From: Plater, Roger - Communities <Roger.Plater@Oxfordshire.gov.uk>
Sent: 02 December 2021 15:52
To: Wayne Campbell
Cc: Transport CDC Minor; DC Support; Cllr Arash Ali Fatemian; Batchelor, Kevin - Communities
Subject: 21-03759-F Land East of The Leys Adderbury

Planning application:	21/03759/F
Location:	Land East Of, The Leys, Adderbury
Description:	Erection of 2 dwellings
Type:	Full Development
Case Officer:	Wayne Campbell

PROPOSED ACCESS ROAD WIDENING DIMENSIONS

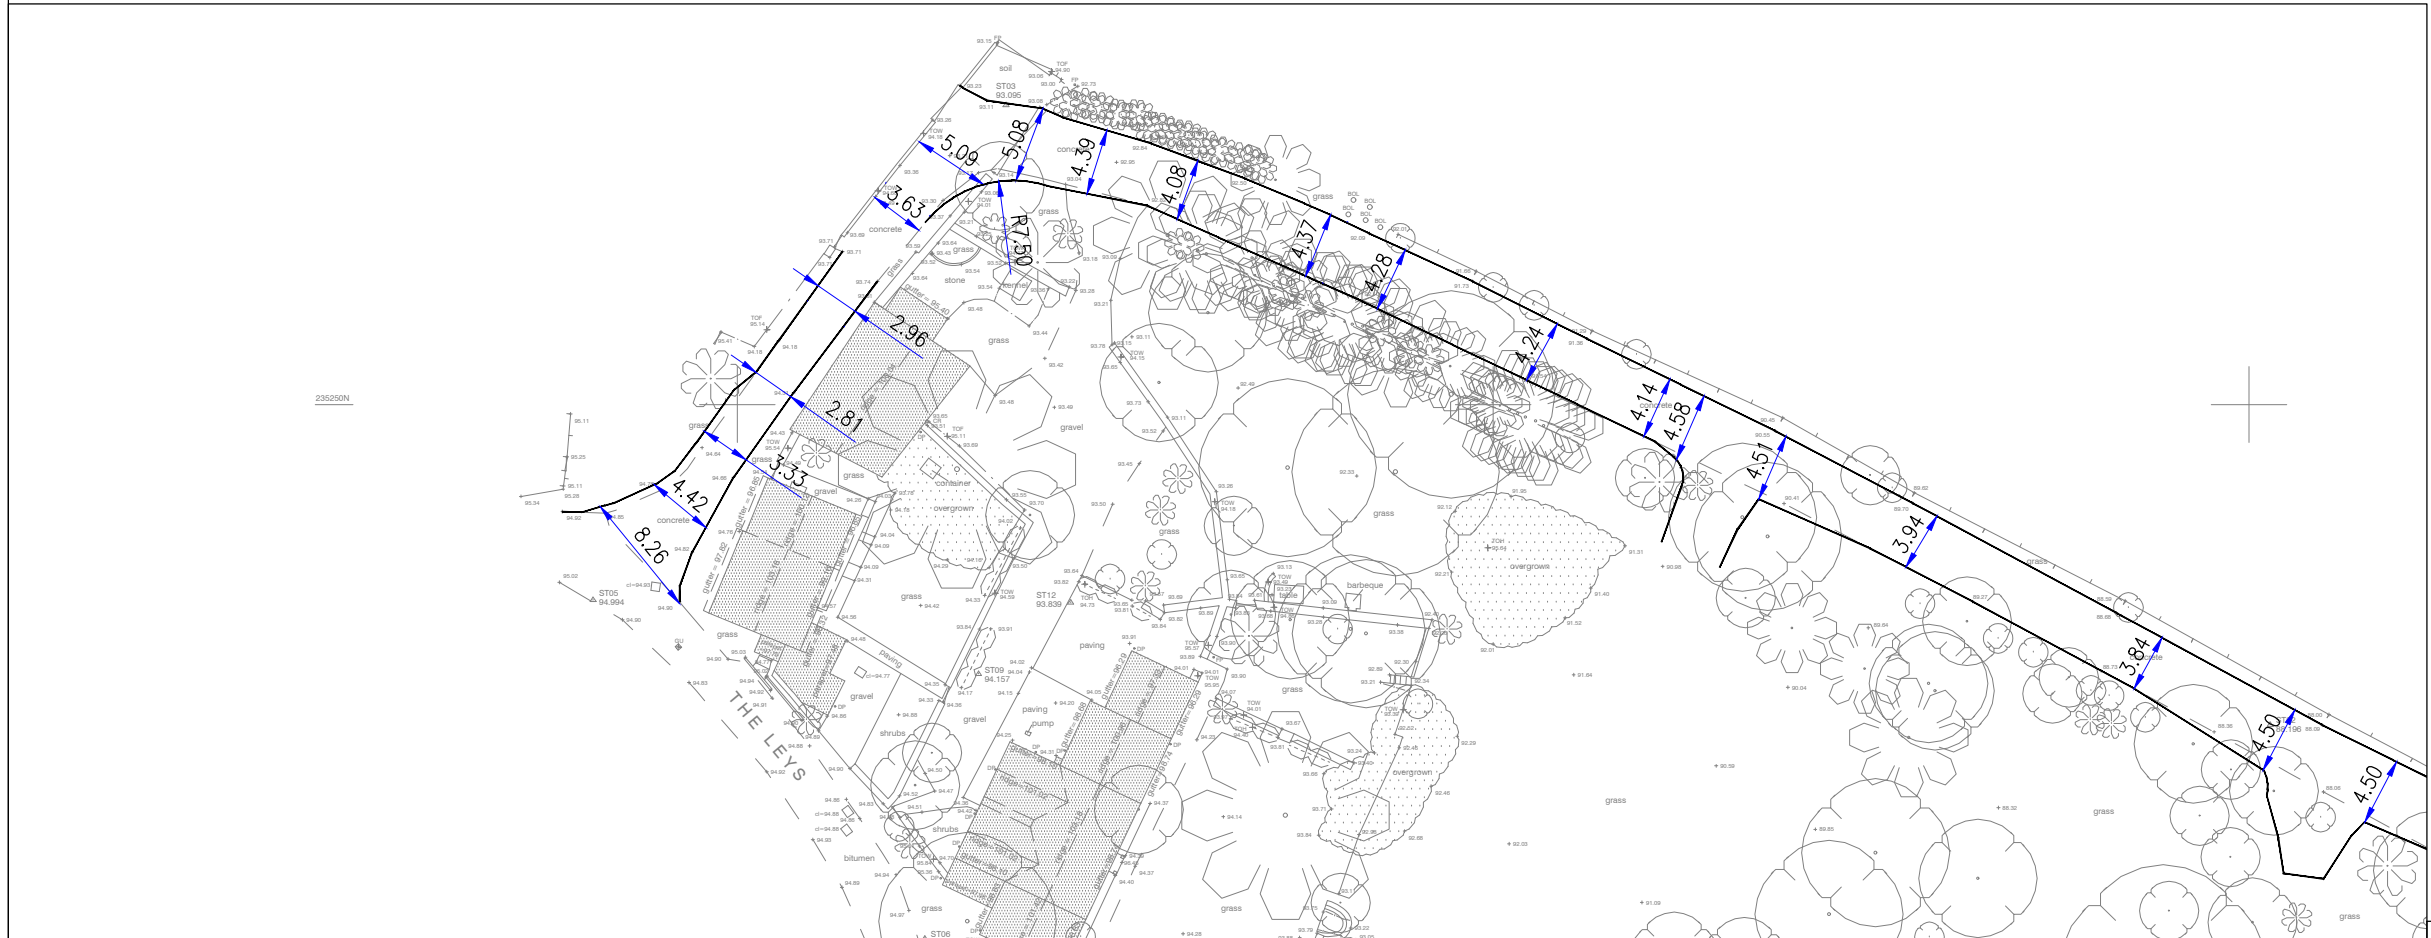
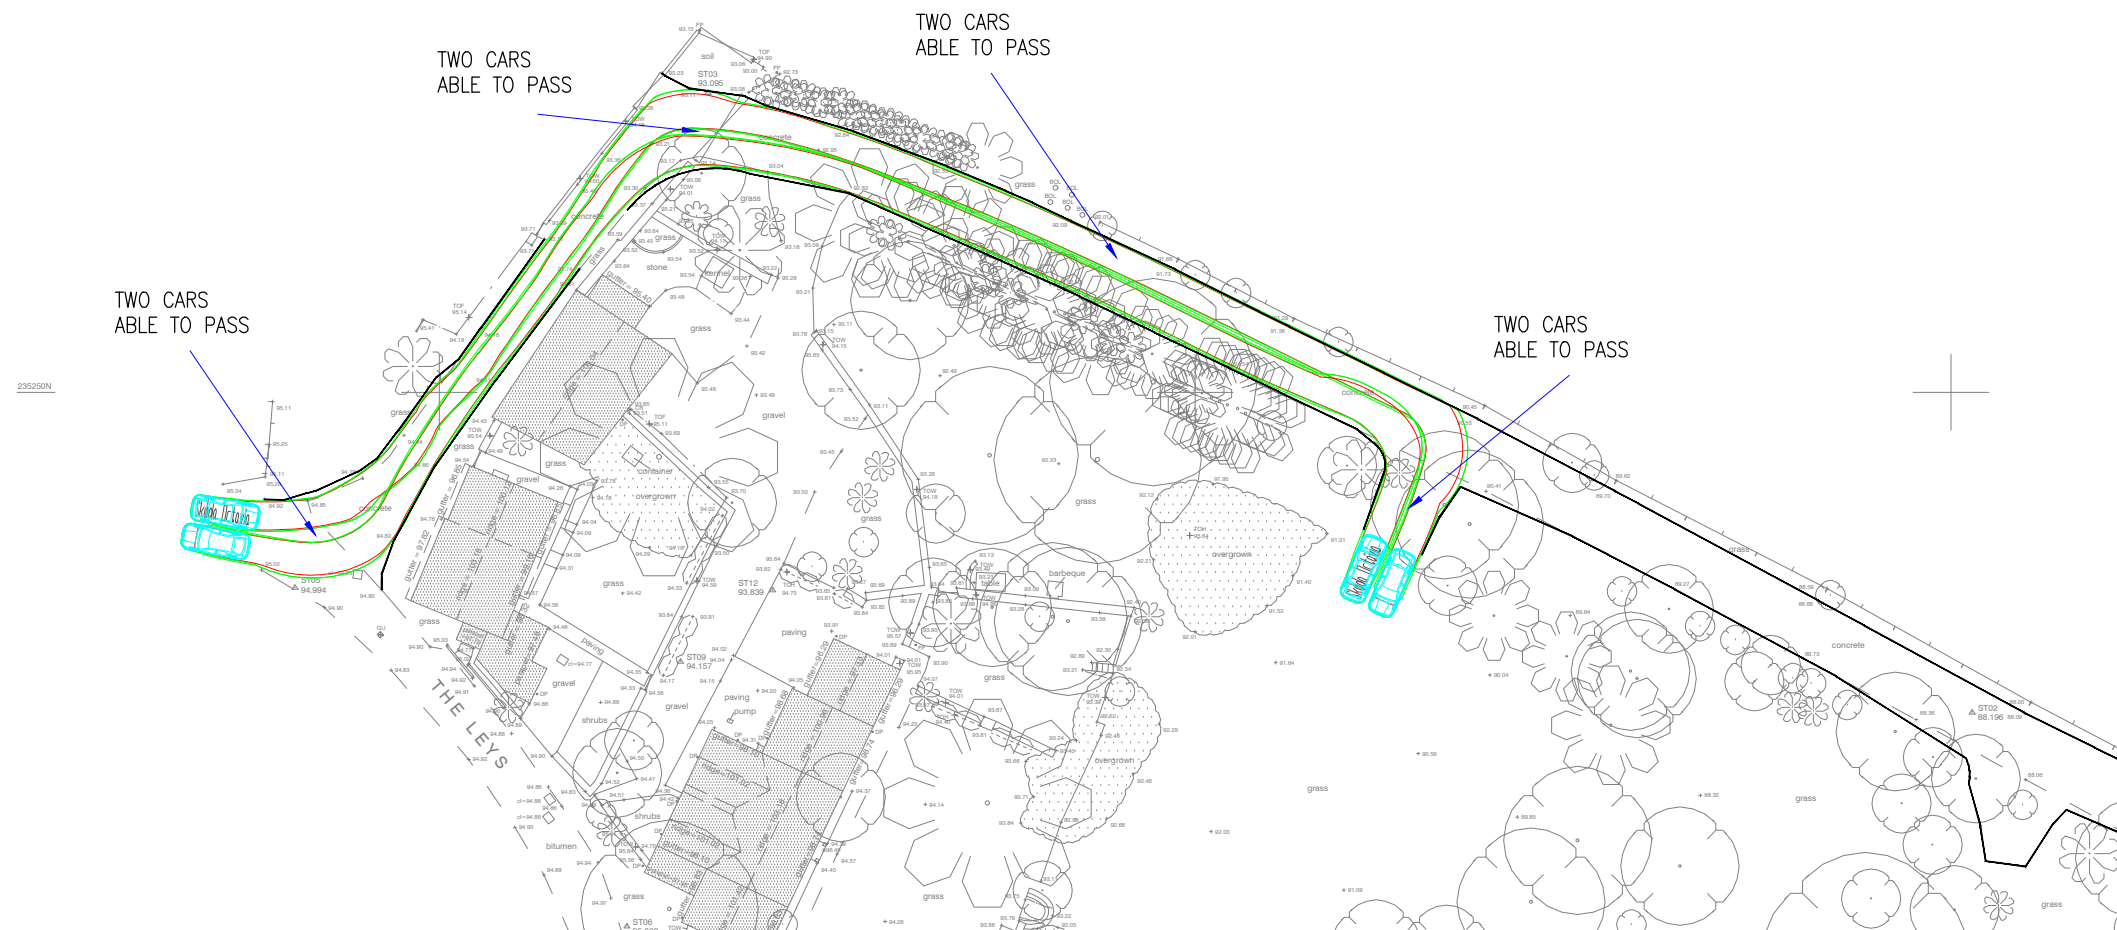
Changes to the proposals include widening of the concrete track where it meets The Leys so that two vehicles may pass and eliminating the need to reverse back out on to the public highway. Further widening along the track will allow two vehicles to pass elsewhere, and the inside of the tight bend will be flattened out and opened up to improve manoeuvrability and visibility.
